<b>Application Ref:</b>	2025/0954			 <b>Ribble Valley Borough Council</b> <small>www.ribblevalley.gov.uk</small>				
<b>Date Inspected:</b>	16/04/2026	<b>Site Notice:</b>	16/04/2026					
<b>Officer:</b>	EP							
<b>DELEGATED ITEM FILE REPORT:</b>					<b>REFUSAL</b>

<b>Development Description:</b>	Proposed demolition of garage, storage building and porch and erection of new single-storey extension to side and rear.
<b>Site Address/Location:</b>	4 Valley View Sawley Road Grindleton Clitheroe BB7 4RP.

Title
Proposed Elevations, Floor Plan,
Site Plan & Location Plan

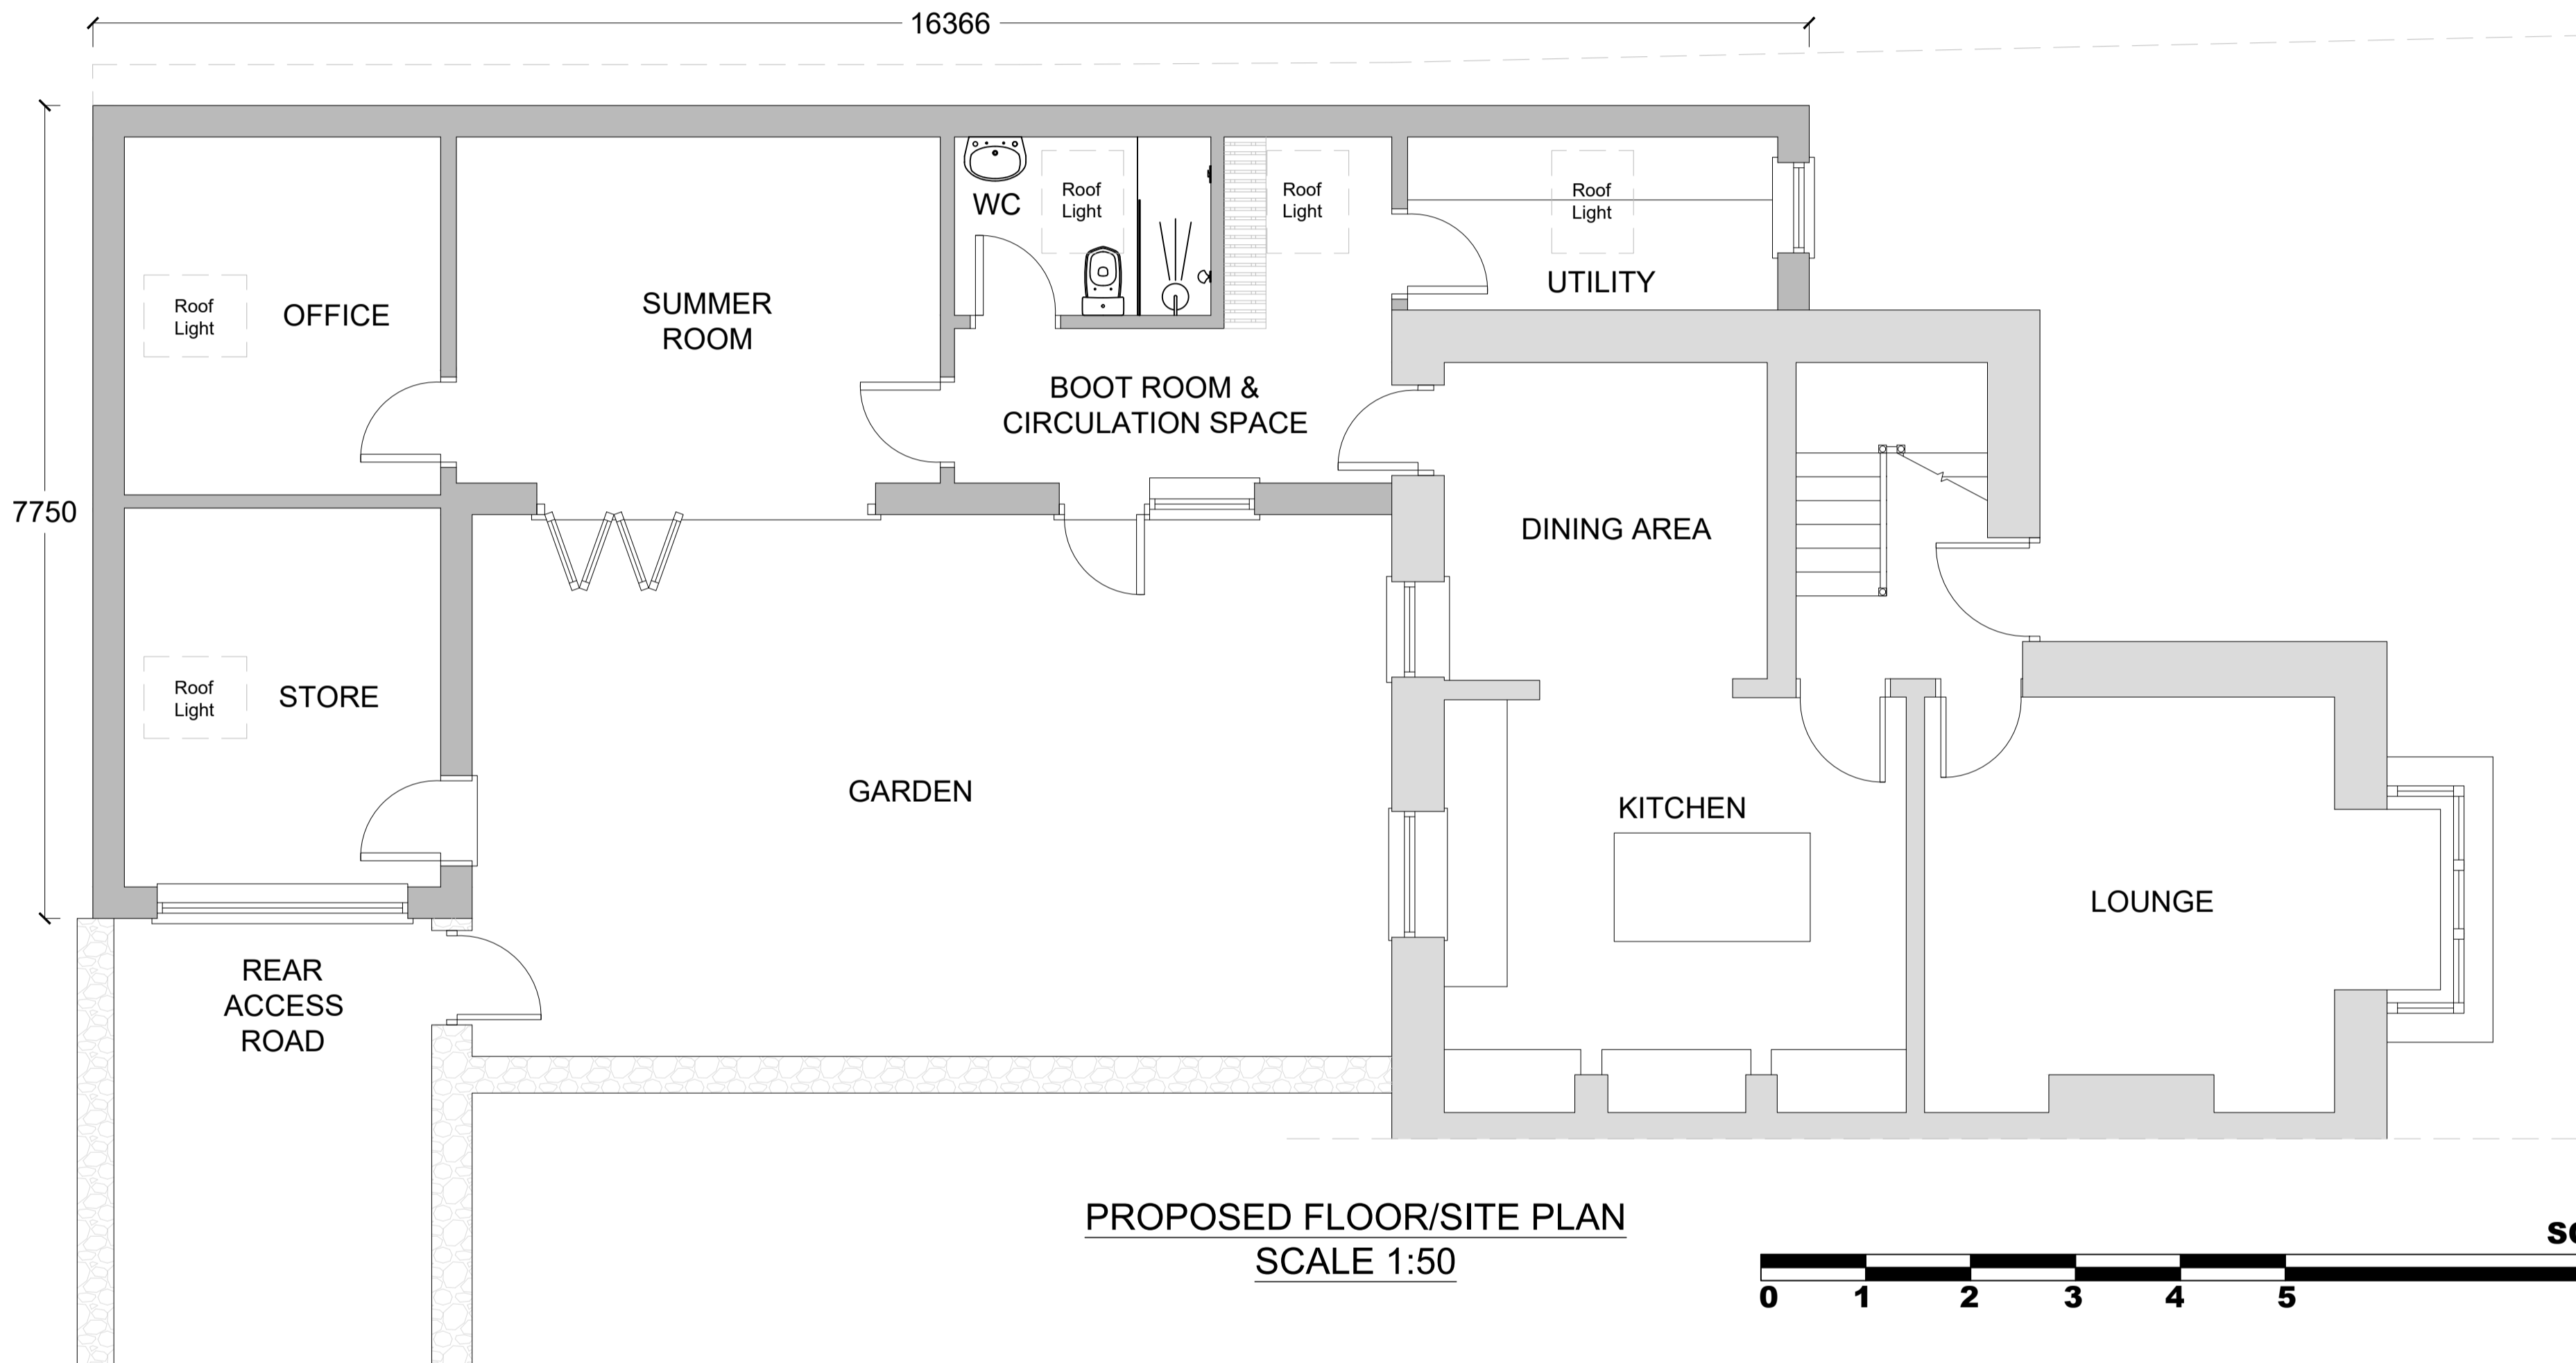
The proposed extension is positioned along the side elevation of the existing dwelling and, although it projects predominantly into the rear curtilage, it would nonetheless remain visible from the public realm and within the Conservation Area. This visibility is intensified by the elevated siting of the host property above the public highway, increasing the proposed extension's visual prominence.

The extension, measuring approximately 16.3m in length and 7.75m at its widest point, adopts an 'L'-shaped configuration. Its substantial rearward projection would result in an anomalous and disproportionate addition that fails to read as a subservient addition to the host dwelling. If constructed, the cumulative built

form would extend roughly 21.5m from the principal elevation to the rear elevation of the proposed works, significantly exceeding the scale and depth of the existing, and immediately neighbouring, property.

Such an extensive projection would create a visually dominant mass that is at odds with the established proportions of the host building. Given its elevated position and subsequent visibility from the public highway, the proposal would introduce a conspicuous and intrusive element that would erode the character and appearance of the Conservation Area.

As such, the proposed extension fails to adopt a subservient position to the host dwelling. Its elevated position, combined with the excessive bulk and massing of the built form, results in a development that competes visually with the host property. The proposal therefore conflicts with Policies DMG1, DMG2, DME4 and Key Statements EN2 and EN5 of the Ribble Valley Core Strategy, which require development to be sympathetic to existing built form, preserve and enhance designated heritage assets and valued landscapes. It is also contrary to Paragraphs 135, 187, 212 and 215 of the NPPF, which emphasise the need for great weight to be given to the conservation of heritage assets and for development to respond sensitively to local character and protect valued landscapes.

The proposed extension would result in the creation of solid built form across the entirety of the northeastern boundary, where the neighbouring property No.5 Valley View is located. The proposed extension will have varying eaves and ridge heights measuring 2.45m and 4m respectively at its tallest point.

Although the neighbouring dwelling itself is set in from the shared boundary and is therefore unlikely to experience significant loss of light or an overbearing impact to habitable rooms, the proposal still raises concerns regarding the impact on residential amenity, particularly in relation to the neighbouring garden space. A large portion of the neighbouring garden would be subject to loss of light and overbearing impact insofar that the extension would result in solid built along the entire boundary. In addition, the neighbouring property is on lower ground level than the application site. This would intensify the perceived height and dominance of the structure when experienced from the neighbouring garden.

As such, the proposed extension, by virtue of its continuous and visually dominant built form along the full length of the north-eastern boundary, together with its height, massing, and the significantly lower ground level of the adjoining property at No. 5 Valley View, would result in unacceptable overshadowing and overbearing impact to the neighbouring garden, contrary to Policy DMG1 of the Ribble Valley Core Strategy and Paragraph 135 of the NPPF.

# PROPOSED SITE PLAN

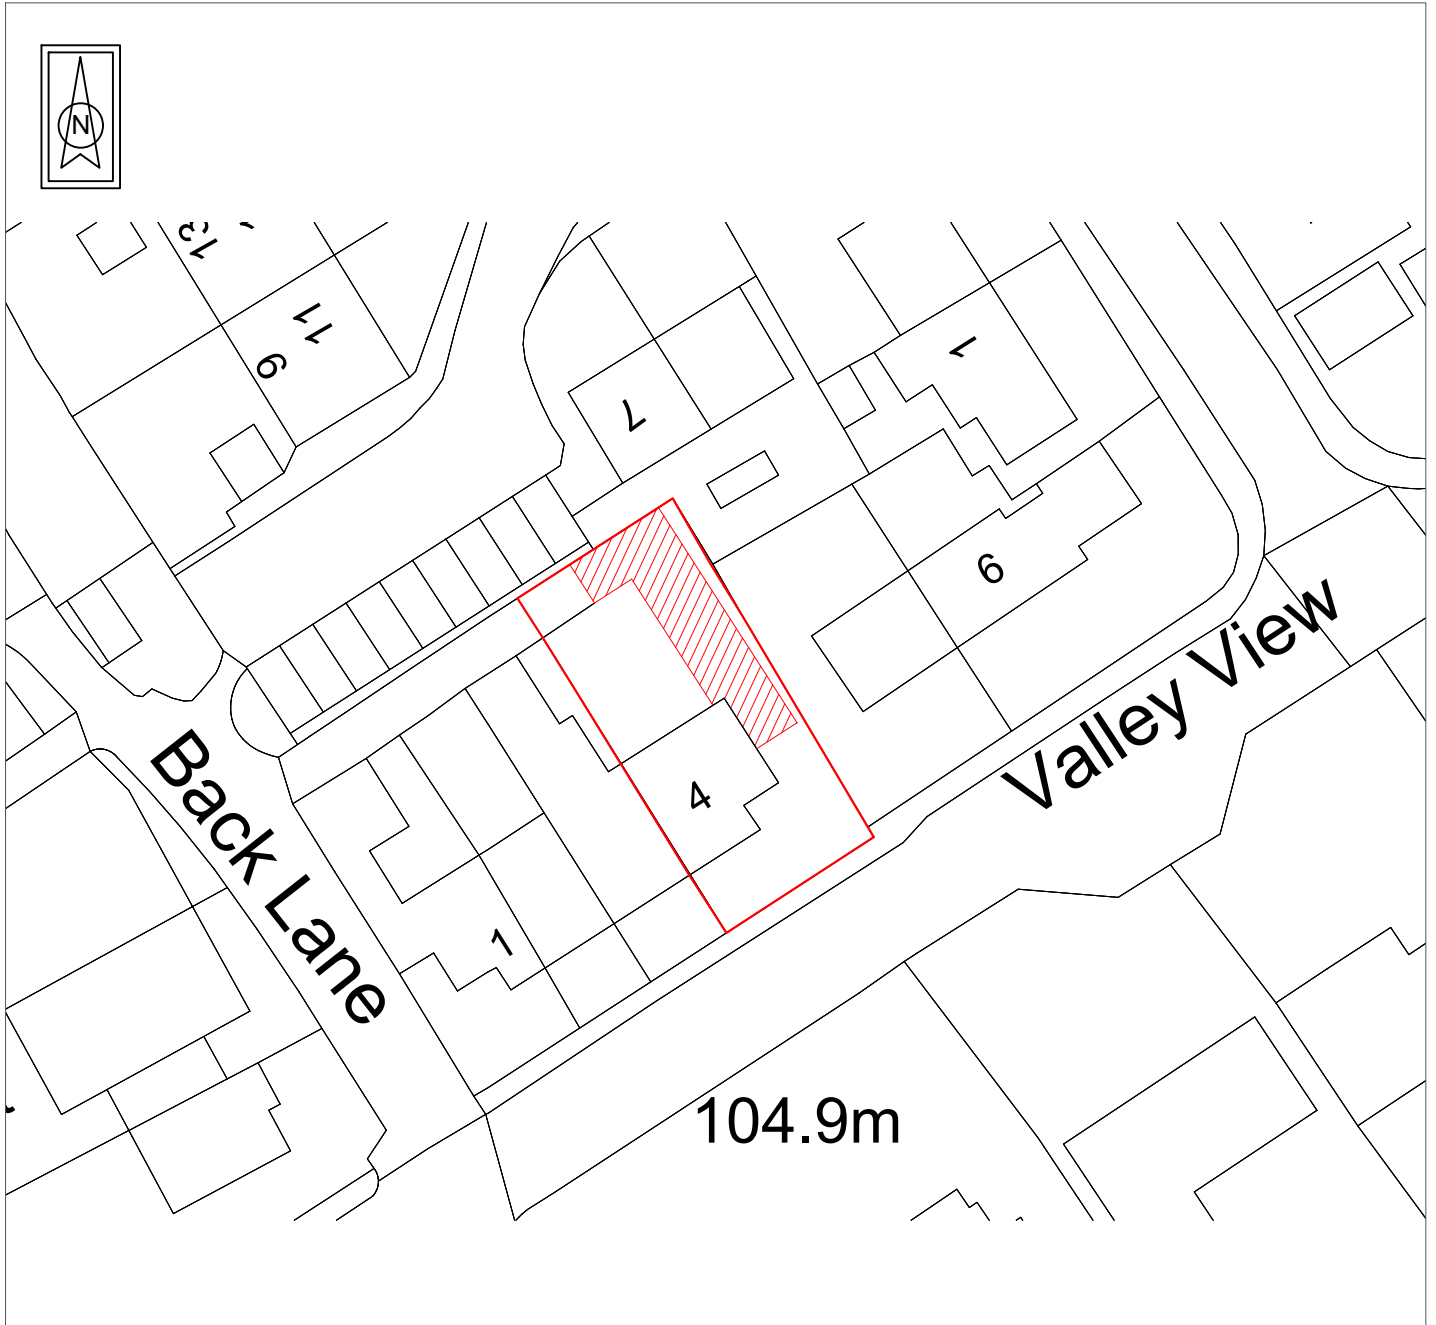
It is acknowledged that an existing 'L'-shaped outbuilding occupies part of the site and would be removed to facilitate the proposed extension. While the configuration of the proposal loosely reflects the footprint of this existing structure, the comparison is limited. The existing outbuilding is detached, and this separation provides a degree of visual relief between it and the main dwelling, reducing its perceived mass and mitigating its impact on the surrounding area. The extension as proposed would eliminate this separation entirely along the north-eastern boundary. The continuous built form created by attaching the extension to the host dwelling would significantly increase the perceived bulk of development on this side of the plot. Without the visual break currently afforded by the detached outbuilding, the proposal would read as a single, enlarged mass, resulting in a form that appears bulky and disproportionate. This intensification would therefore exacerbate the extension's visual prominence and therefore the development fails to appear subservient.
